Our Case Number: ABP-312606-22

Your Reference: Ballinagree Wind DAC

Re: Wind farm development of 20 turbines with 110kV electrical substation and all related site works and ancillary development.

Please be advised that the Board, in accordance with section 37(F)(1) of the Planning and Development Act, 2000, as amended, hereby requires you to furnish the following further information in relation to the effects on the environment of the proposed development: .

PROJECT	CLIENT		
BALLINAGREE WIND FARM	BALLINAGREE WIND DAC		
SHEET	Date	15.12.21	Project number
	Drawn by	NS	P2114
	Checked by	TB	Drawing Number
PROPOSED WATERCOURSE CROSSING DETAIL - WF-HF8		P2114-0300-0017	
		Scale (@ A1-) AS SHOWN	Rev B

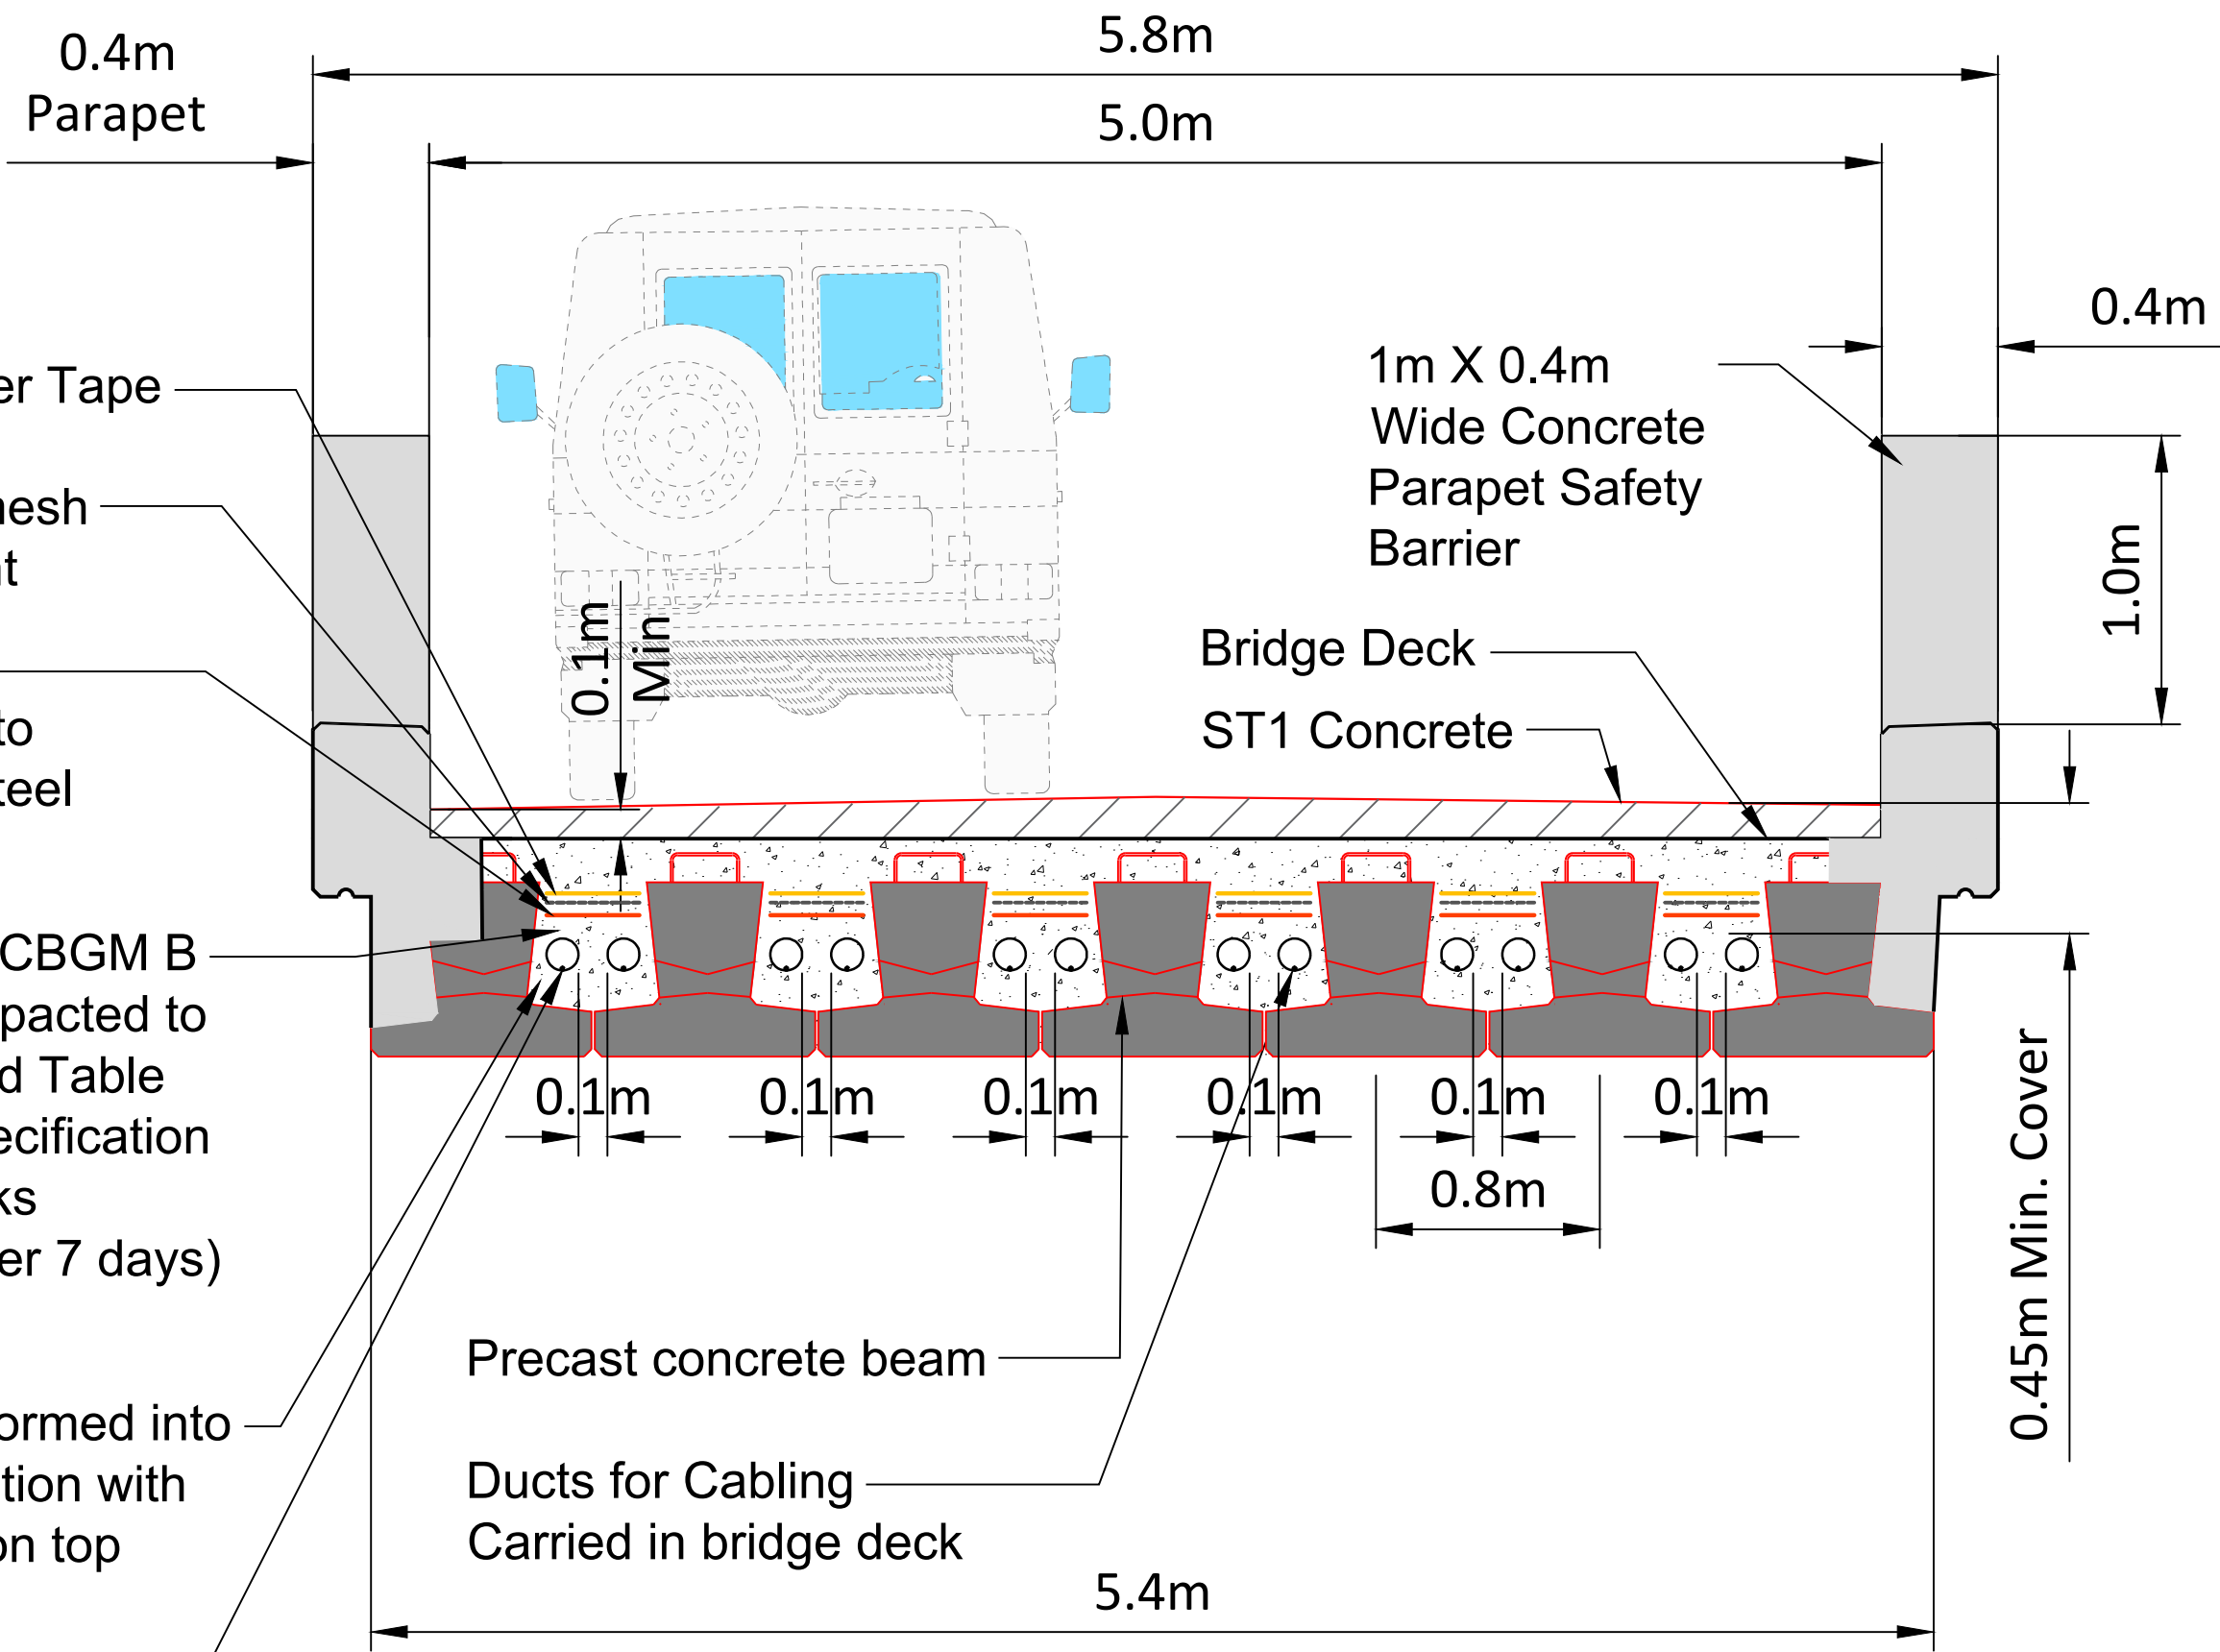
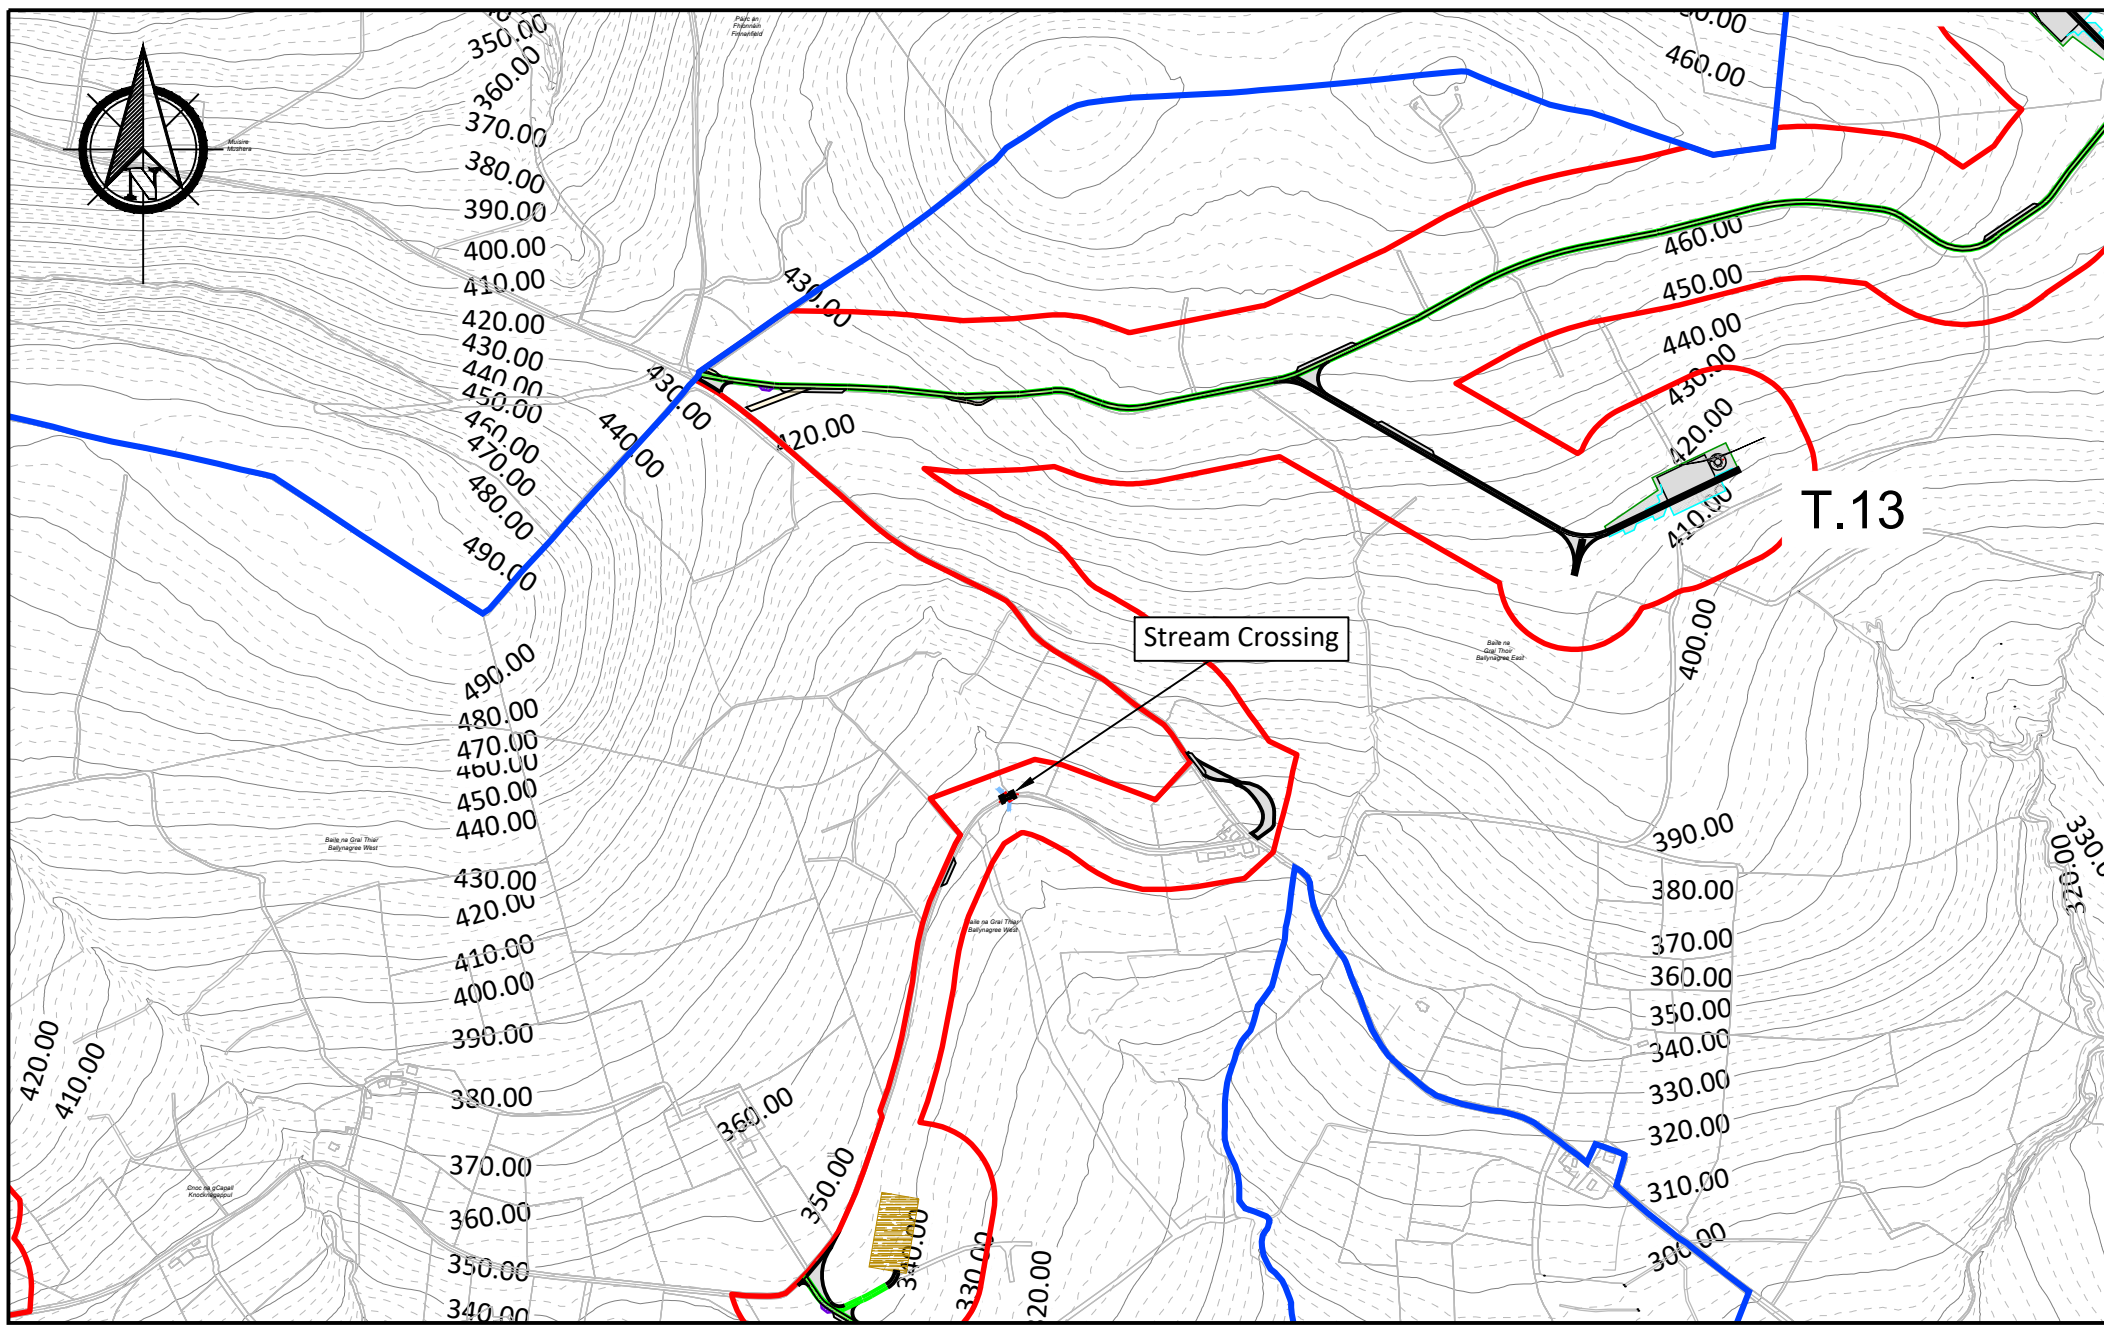
- (d) Confirm whether the design of watercourse crossings WF-HF5 and WF-HF8 complies with OPW requirements.
